**Plane Street  
Huddersfield**

**Stage 1 Road Safety Audit**

<b>Report Ref:</b>	11294/AND/001/01	June 2020	
<b>Author:</b>	Adam Darwin		
<b>Checked &amp; Approved:</b>	Simon Burkinshaw	<b>Date:</b>	24 <sup>th</sup> June 2020

PLANE STREET
PLOTS 19 AND 20 PLANS AND ELEVATIONS

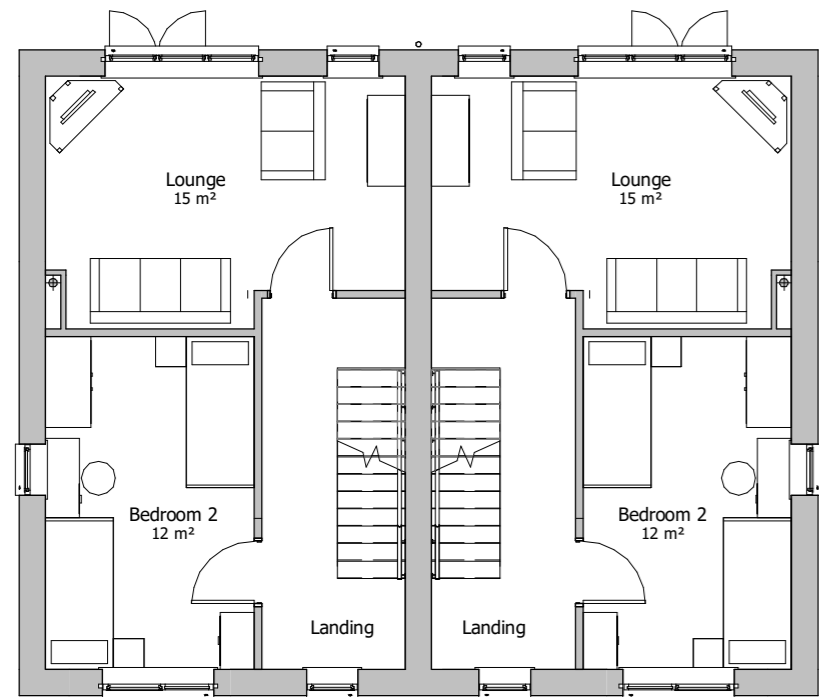
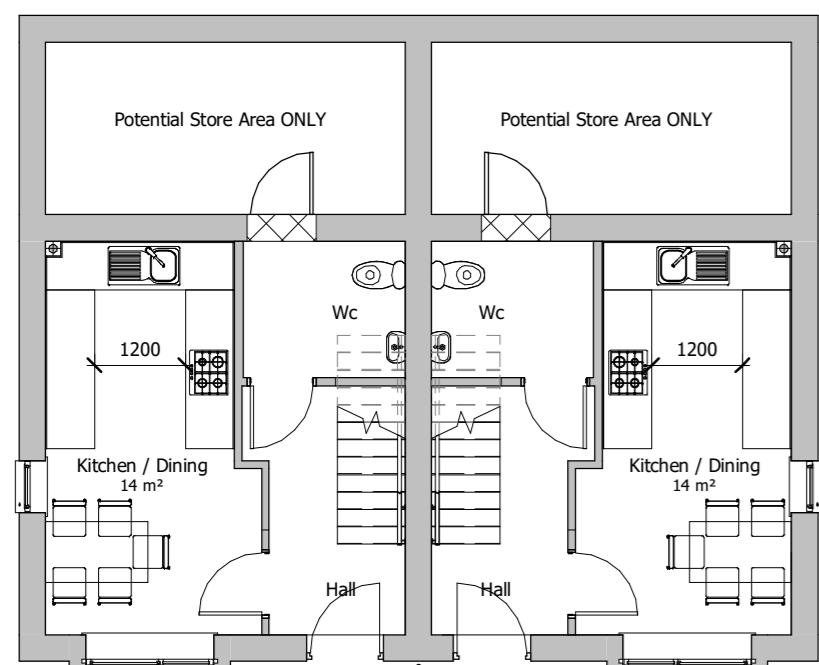
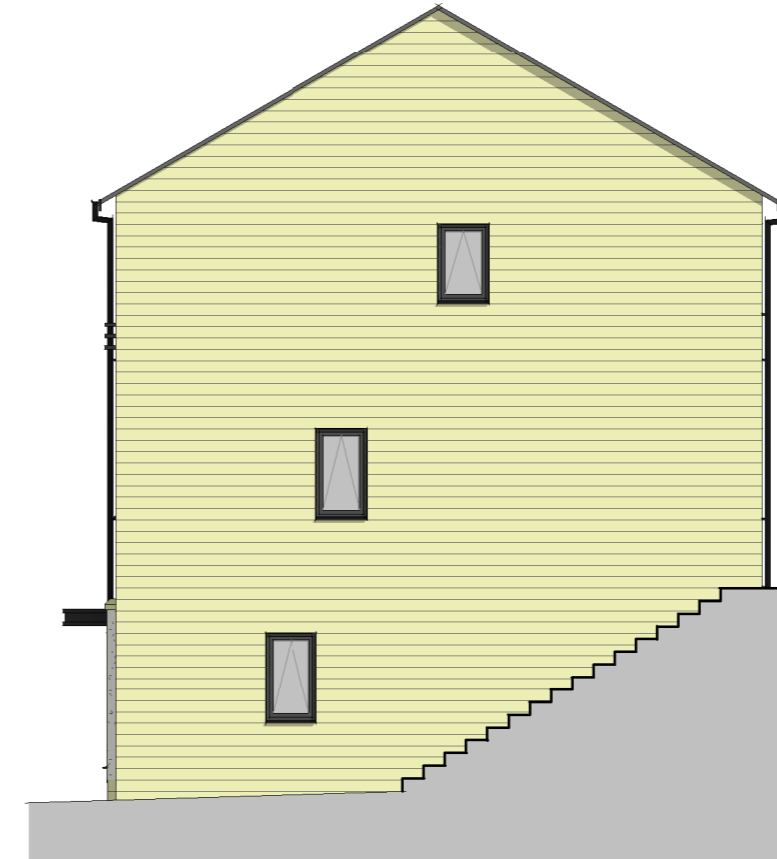
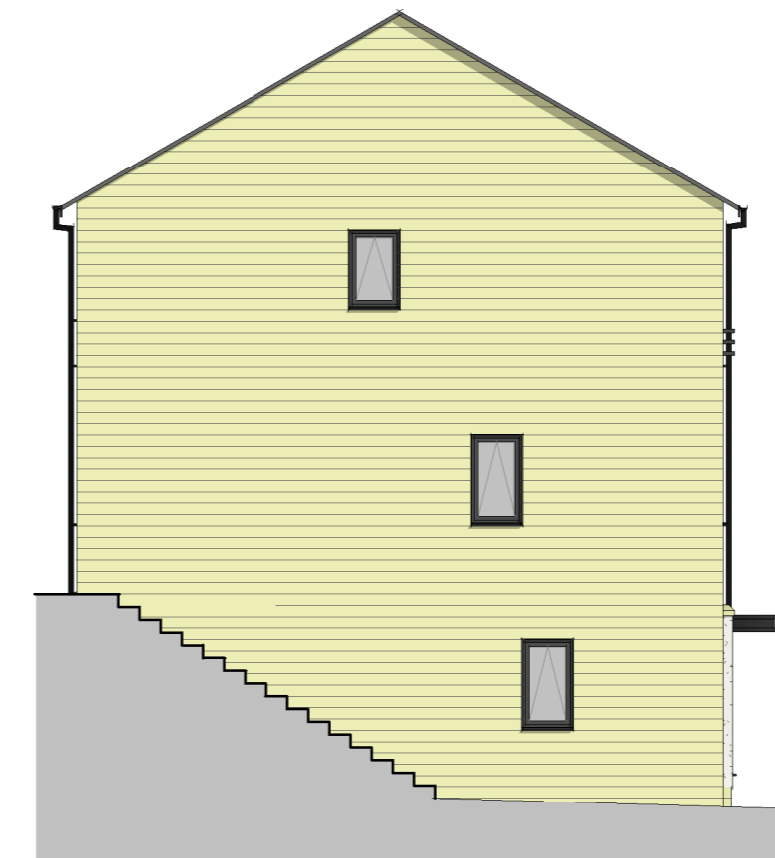
**Summary:** There is only 1 visitor parking space provided towards the western end of the site access road, adjacent to the proposed turning head. As such, visitors or those residents within only 1 parking space may choose to park within the immediate vicinity of the turning head. Should this occur, this could prevent refuse vehicles and other larger vehicles from turning in the highway. This could then result in these large vehicles needing to reverse a long distance around a relatively tight bend and subsequent junction to exit the site, which could result in collisions with other roads users.

**Recommendation:** It is recommended that additional visitor parking spaces are provided towards the western end of the site access road, which appears possible by amending the single visitor parking bay in front of No. 19-20.
